From: Tybie House <[REDACTED]>
Sent: 05 June 2026 17:55
To: Neil Crowther
Cc: Karl Roberts
Subject: Re: A/44/26/PL - Application of National Standards

DRAINAGE (SHEET 1)

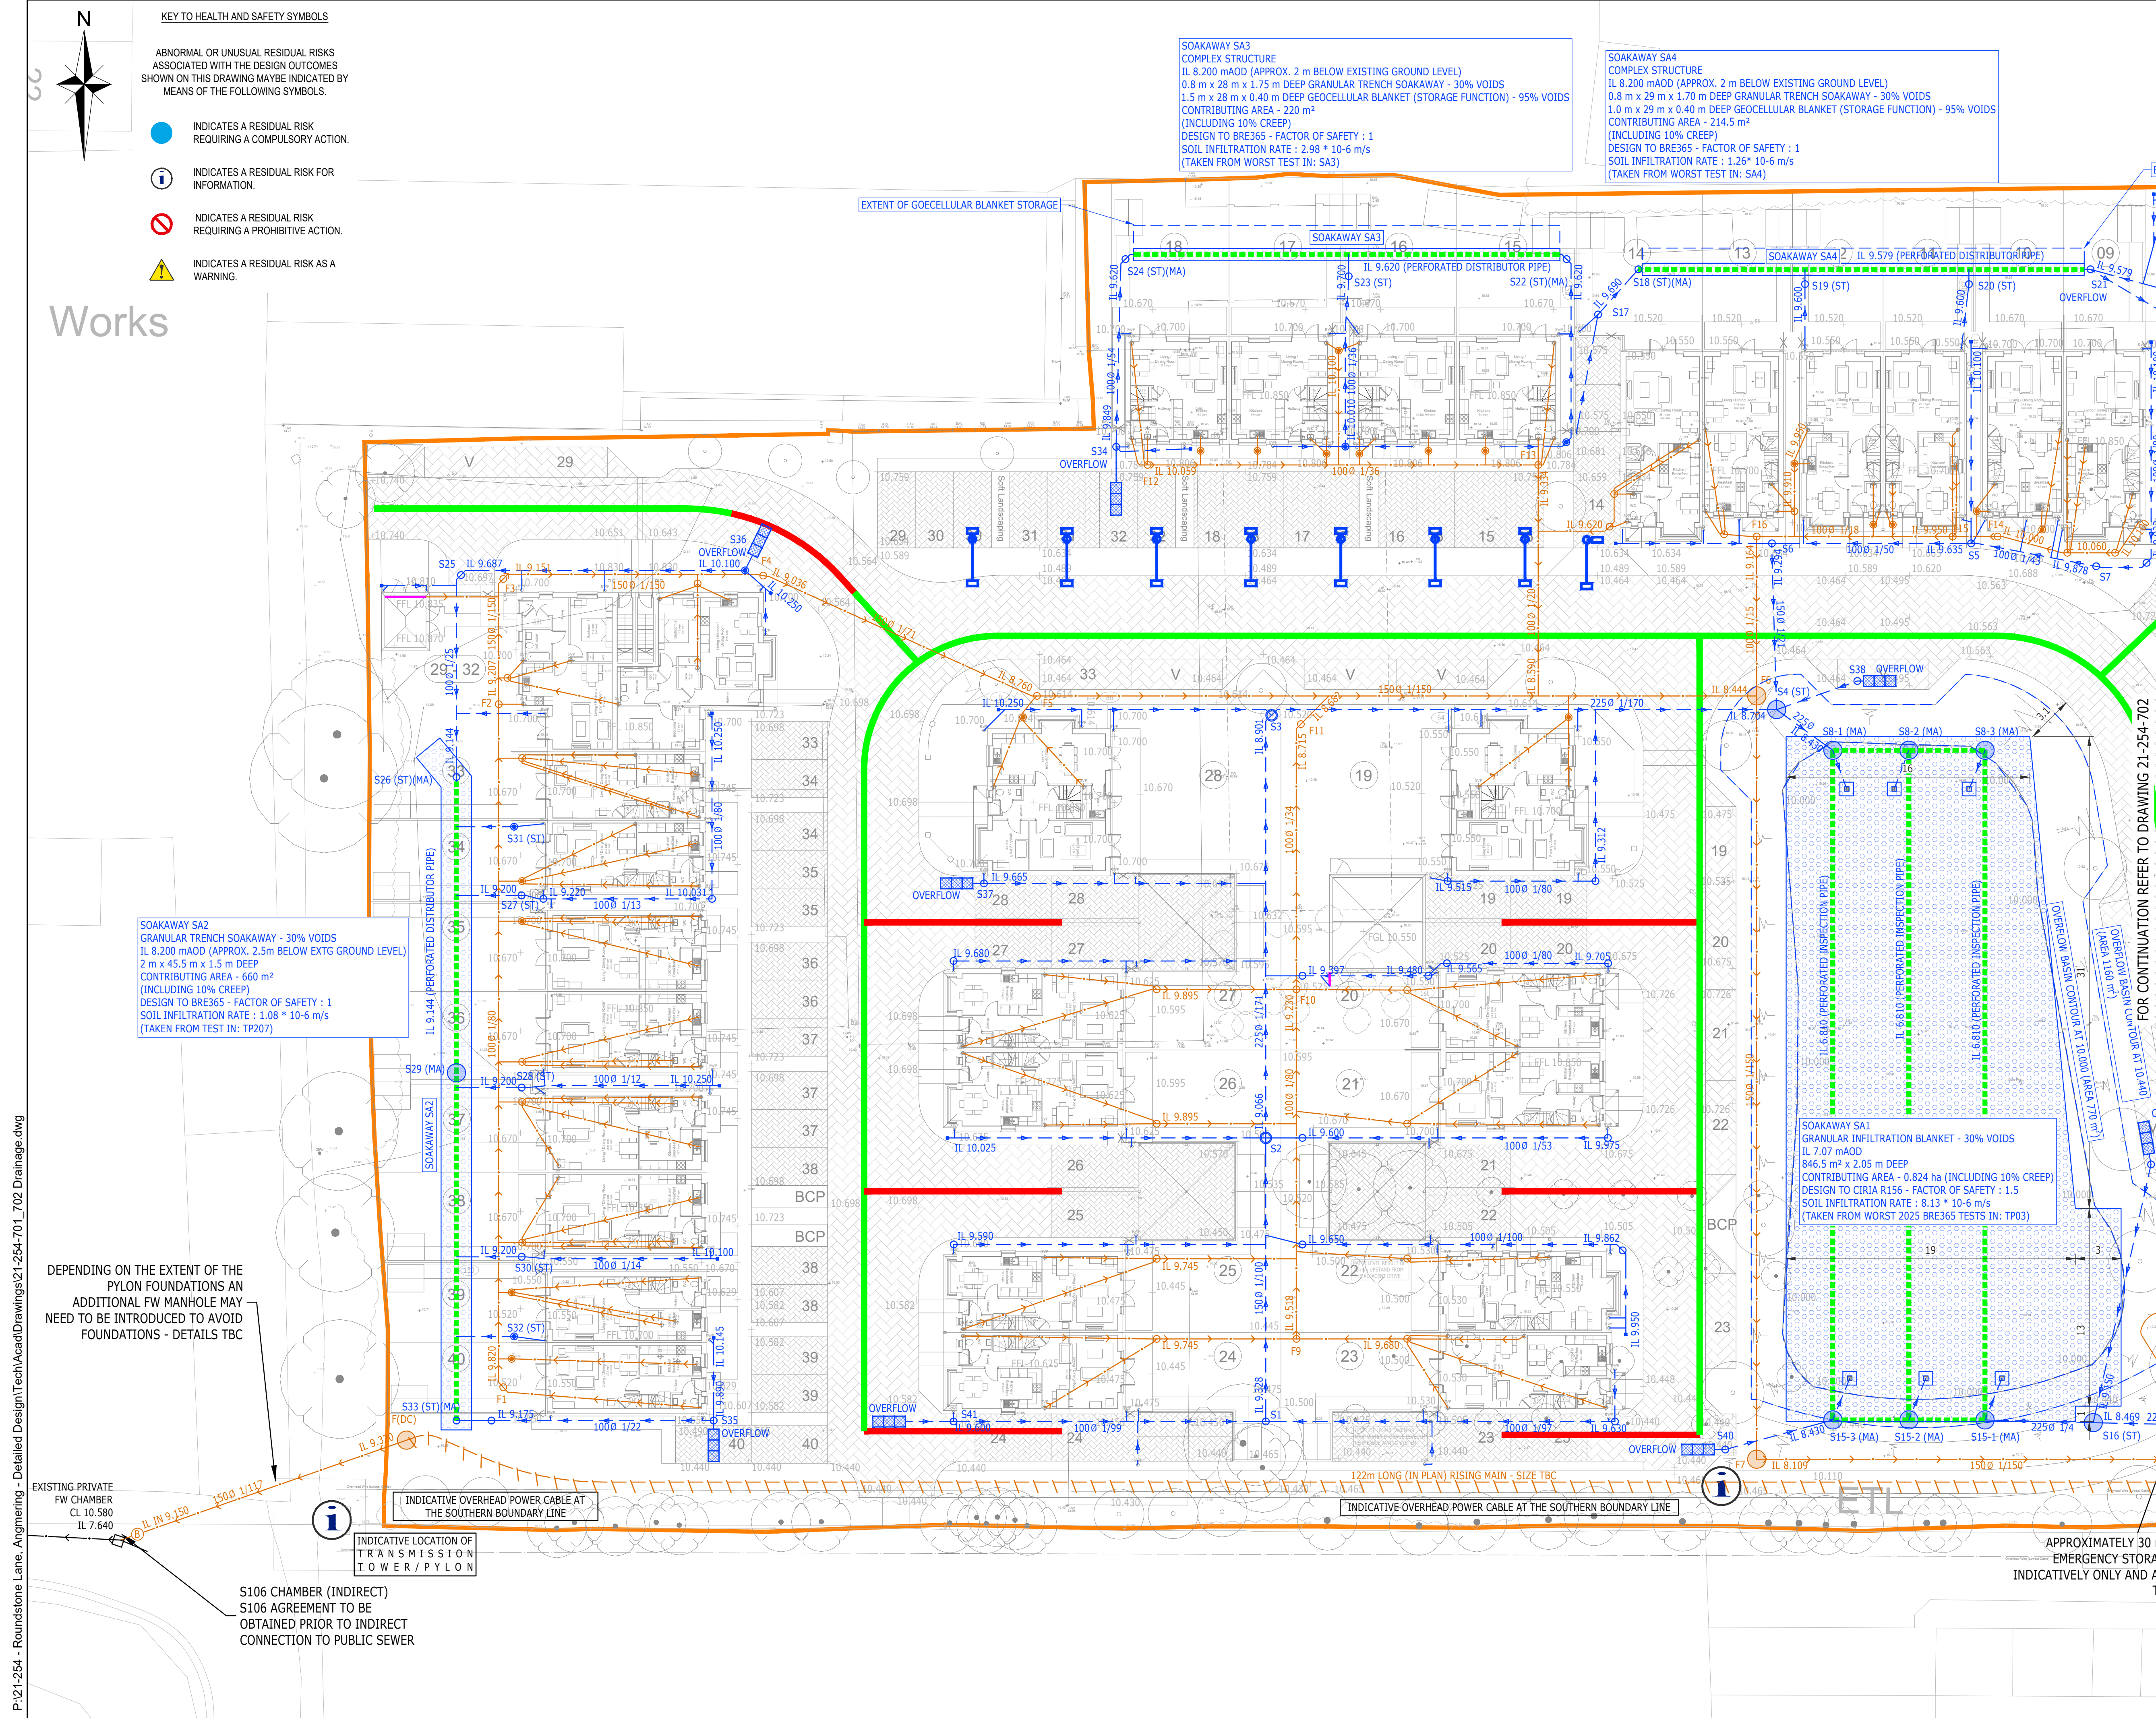
The LLFA stated in relation to the previous application that BRE365 requires testing to be undertaken in ground conditions which replicate the worst-case scenario. The applicant's own data appears to demonstrate that those worst-case conditions occurred in mid-February. As also shown previously, the ground conditions encountered during the April testing followed a particularly dry period. It is therefore difficult to reconcile how those April conditions can properly be said to replicate the conditions required by BRE365.

The concern is that, if this design is based on unreasonably favourable infiltration results, as appears to be the case, the real-world situation is likely to be significantly worse than the submitted design assumes. Over time, that could result in the system as proposed failing because of an inability to drain properly, with a detrimental effect on all residents of the site.
